Tarmac Cycle Path

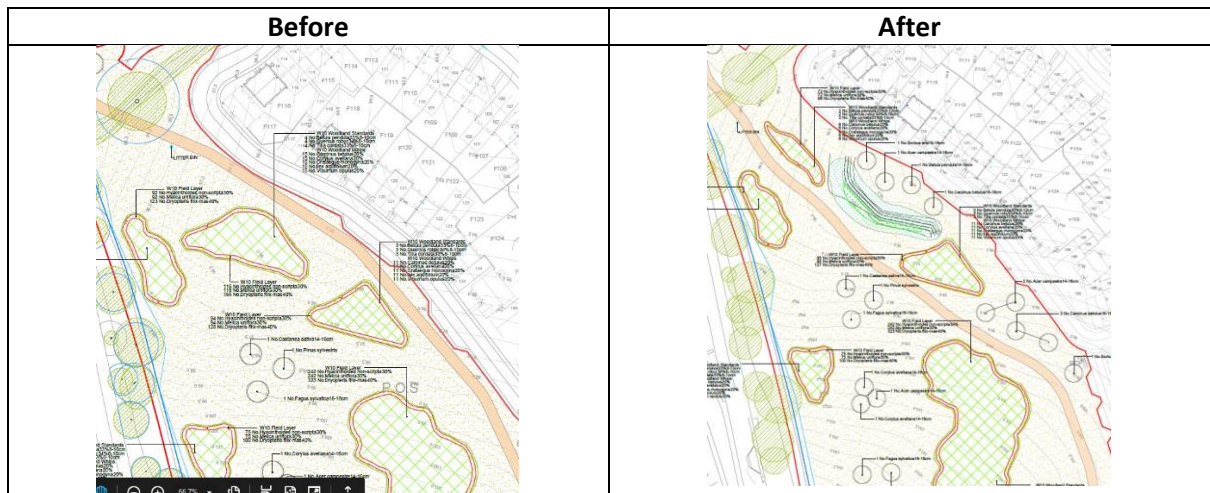
It is important to reiterate that we feel strongly that the changes to levels and the revised path layout were undertaken without any consultation or discussion with residents affected and the 'as-installed' solution for which Taylor Wimpey are seeking retrospective approval is not the optimum solution and is being delivered as a 'fait accompli'. Aesthetically the changes to levels have destroyed what was a significantly more aesthetically pleasing outlook for residents of Longdon Crescent and Hodges Close particularly. Notwithstanding potential challenges with pathway gradients, which appear not to be an issue in other areas of the park, the overriding objection is that the design should revert as closely as possible to the original plans submitted and which were shown to residents as part of the sales process.

Whilst there are some potential benefits of the path being relocated further away from Longdon Crescent the revised route of the path also makes access to the community park by residents of the crescent considerably more difficult. In direct dialogue with Taylor Wimpey, we had requested the addition of a short Hoggin Path, in the approximate location shown on the image below, to reconnect the crescent to the revised path route but this has been rejected by Taylor Wimpey.

In addition, due to roadway kerb heights in the crescent being no more than 30-40mm providing no protection against vehicles for access or parking from the crescent, we requested the installation of a knee rail timber fence similar to that installed in numerous other areas of the park. This request has also been rejected by Taylor Wimpey.

Requests for additional trees and appropriately located vehicle bollards on the cycle path have been acknowledged but not incorporated into the plans submitted for approval.
